**SSD 6626 - SICEEP Darling Square - Mixed Use Residential  
Building within North-East Plot**

**21 November 2014**

## SSD 6626 Submission

21st June, 1pm

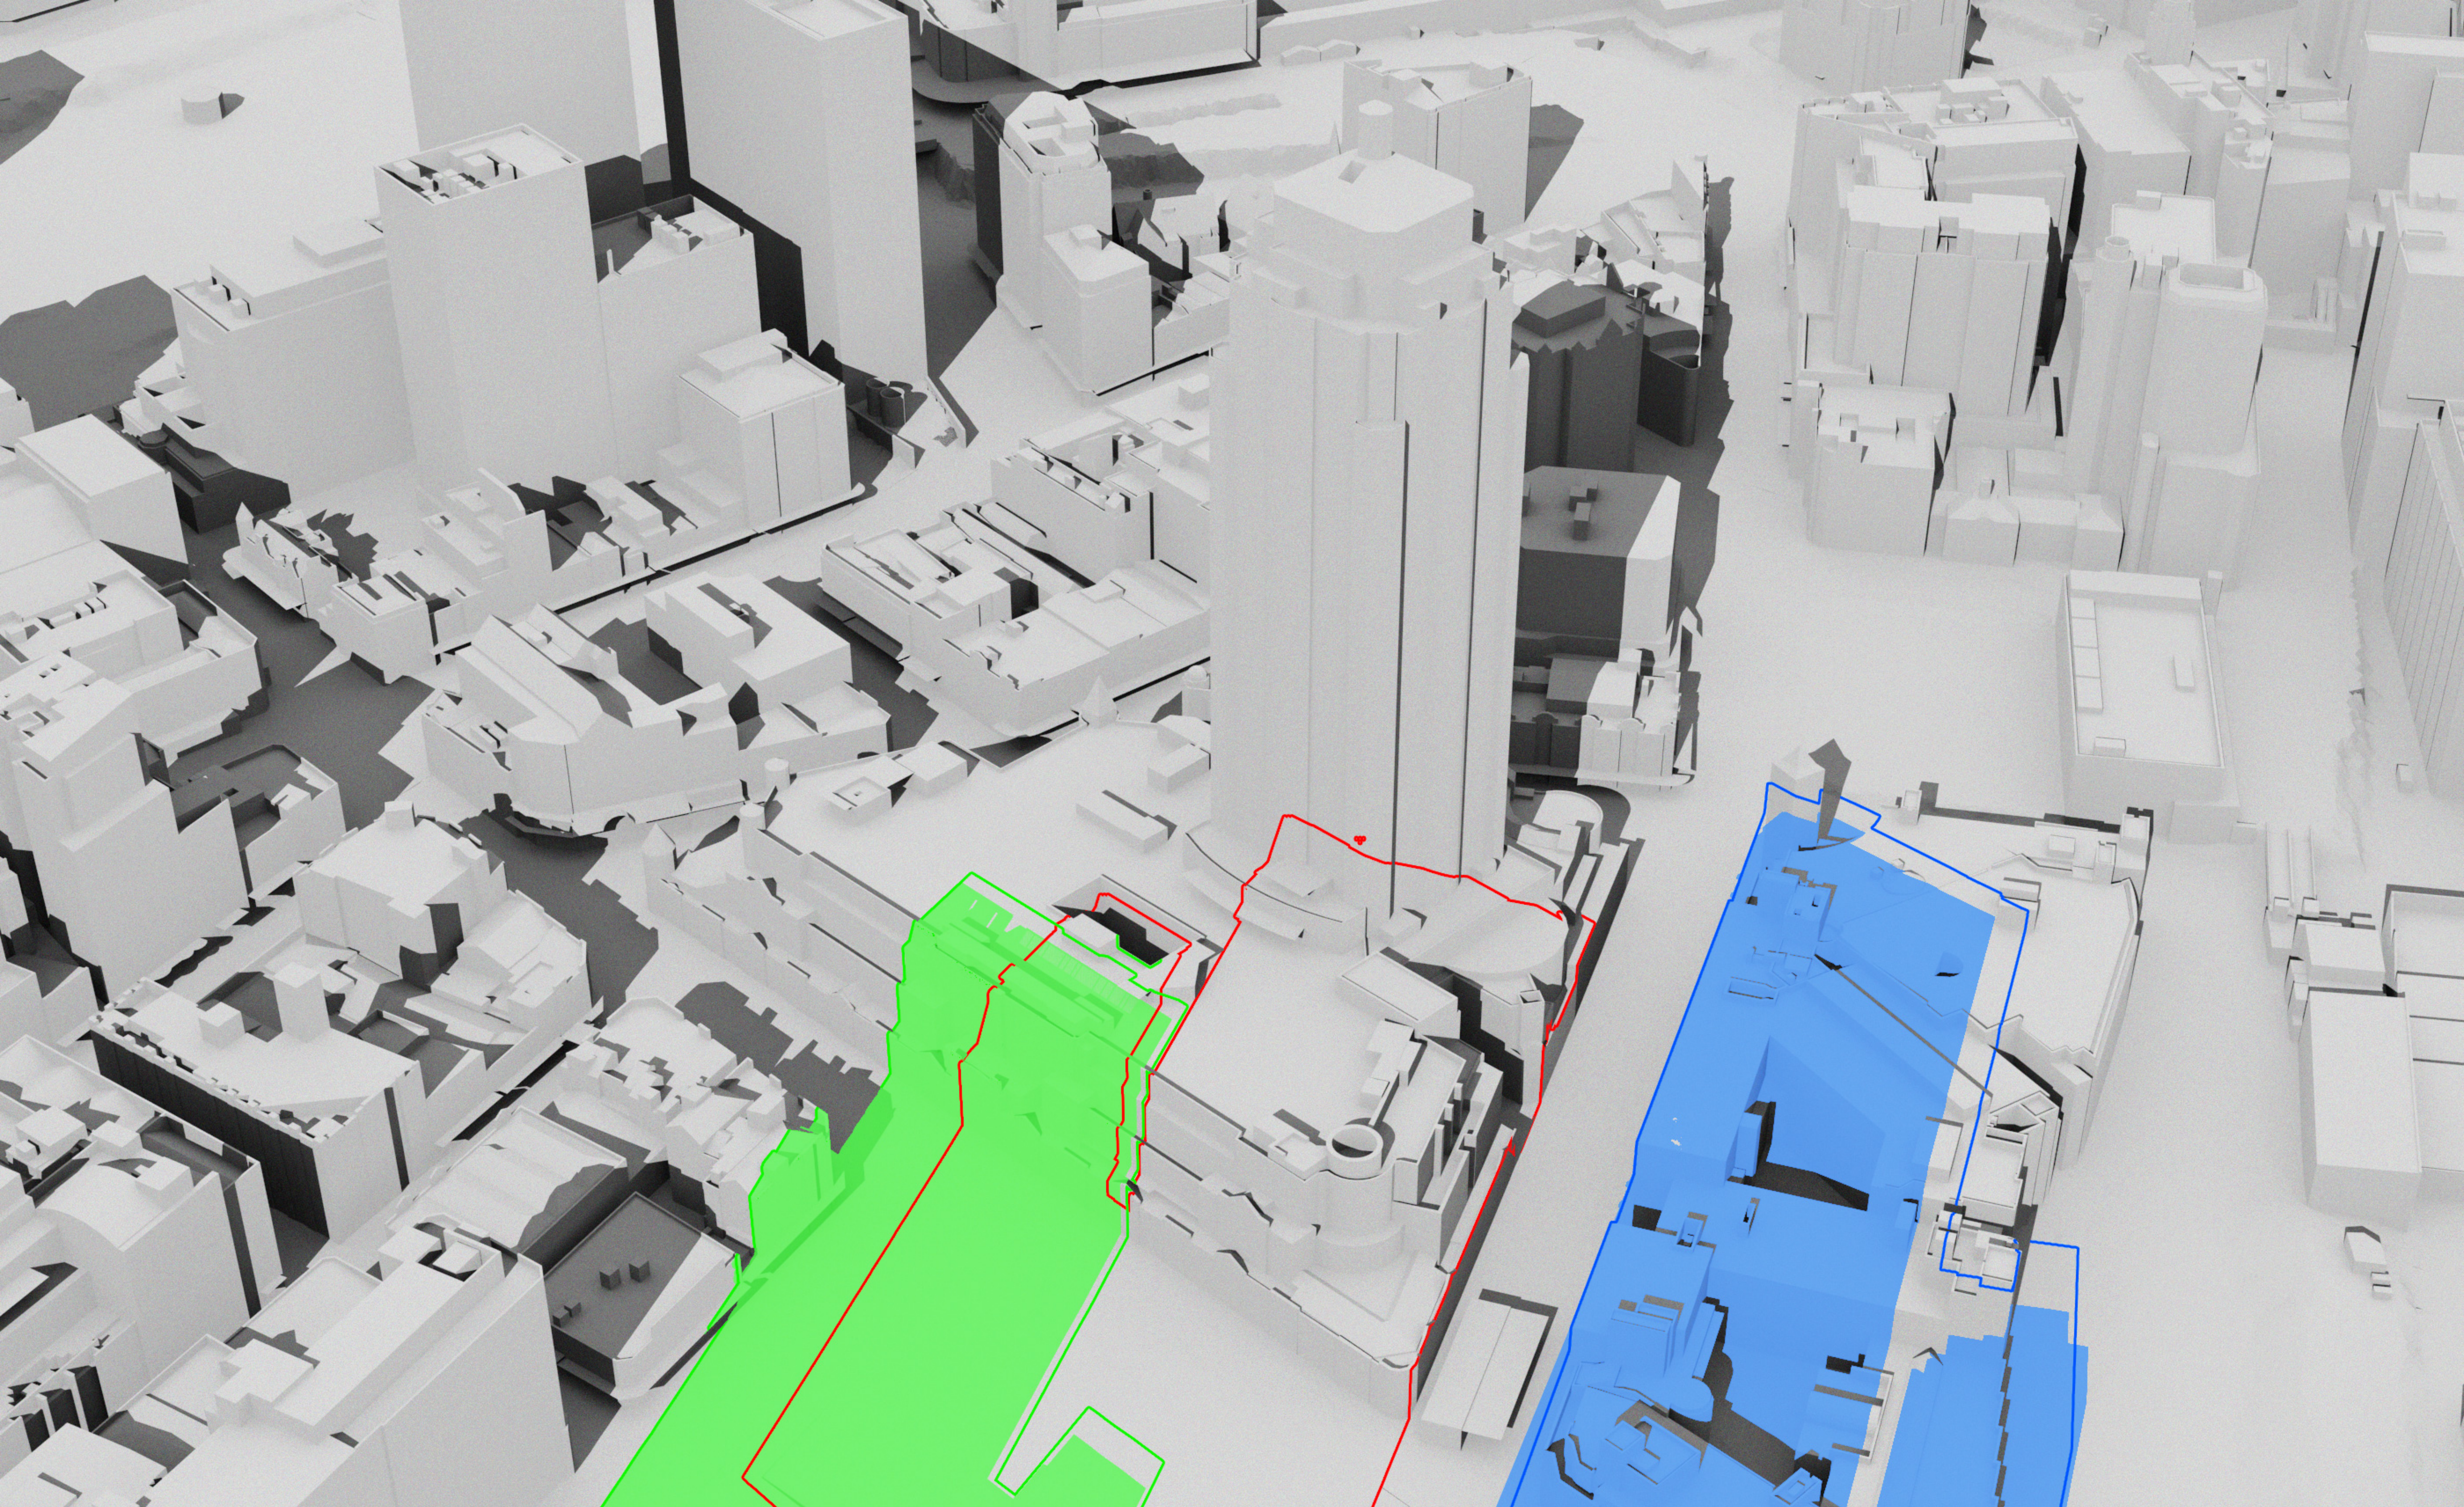
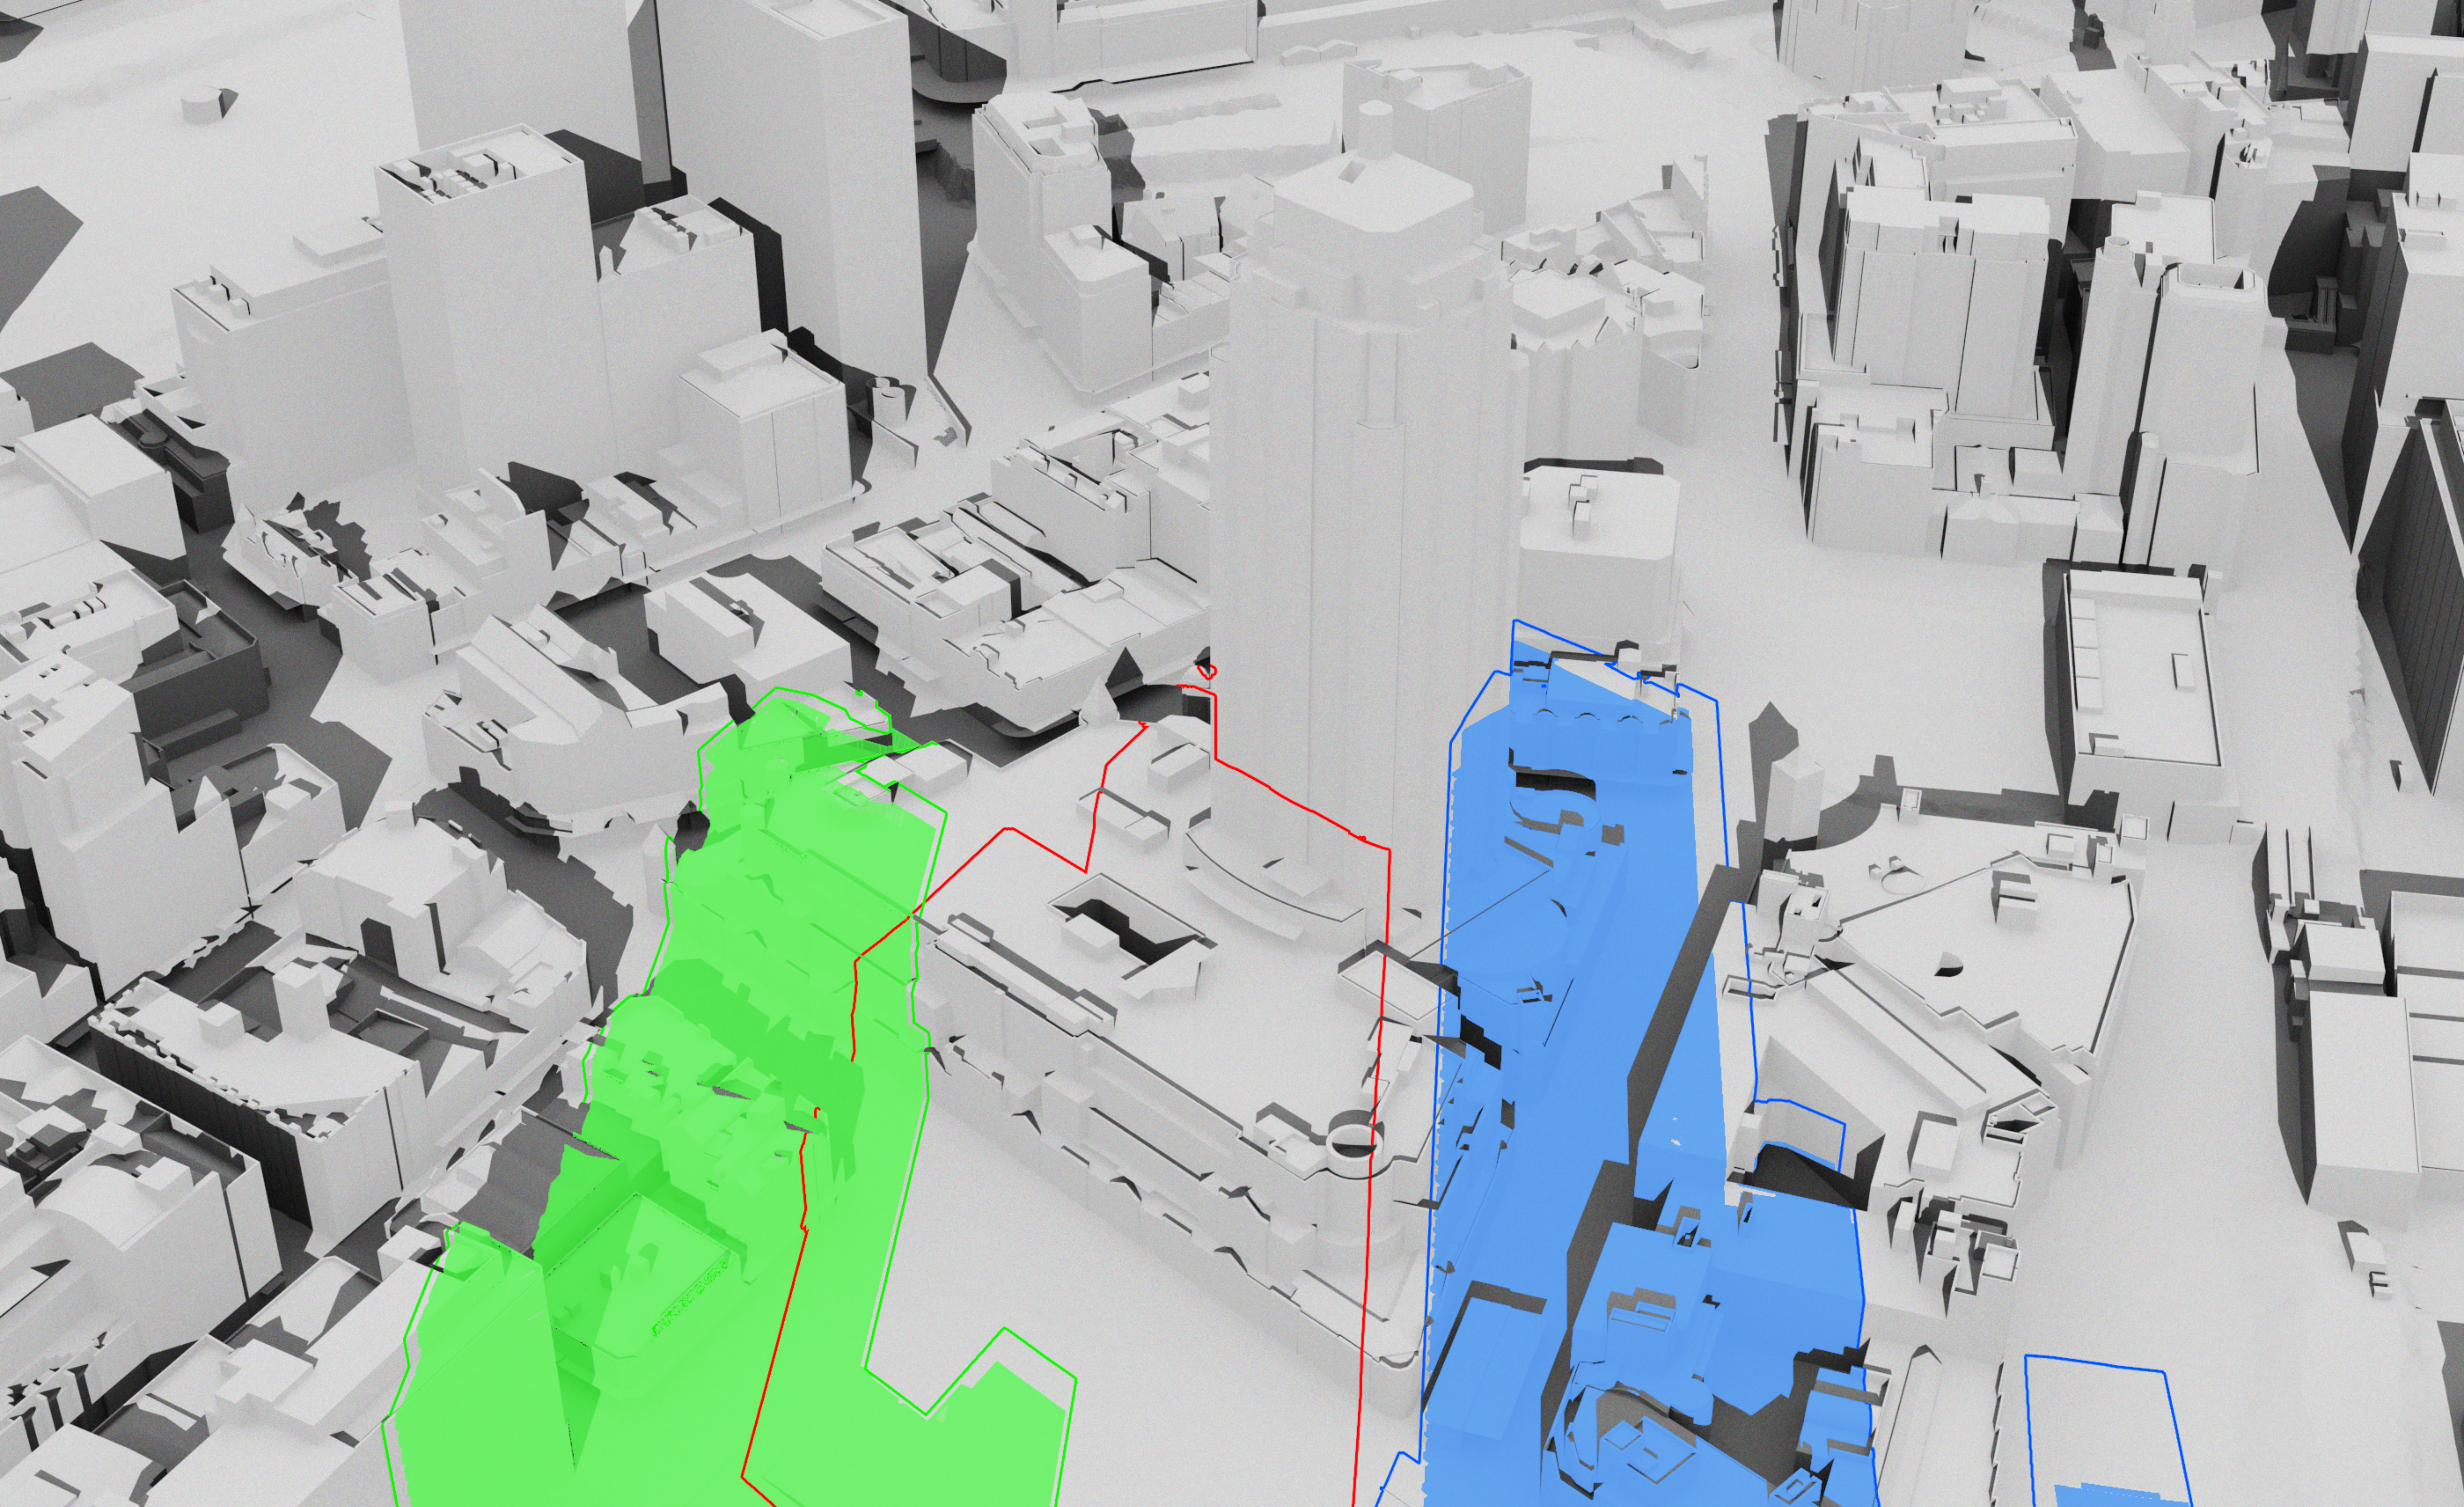
## **Excessive overshadowing of public open space - the new square - "Haymarket Square"**

We agree with the City of Sydney's view that "excessive morning shadows are cast into the outdoor and café areas in the new square by new surrounding building edges. In order to improve morning sun access to the square in winter, it is recommended that the building heights lining the new square be reduced and the floor area relocated to the surrounding streets podium edges..." Source: City of Sydney, SSD 5878 (SICEEP) The Haymarket submission, page 34.
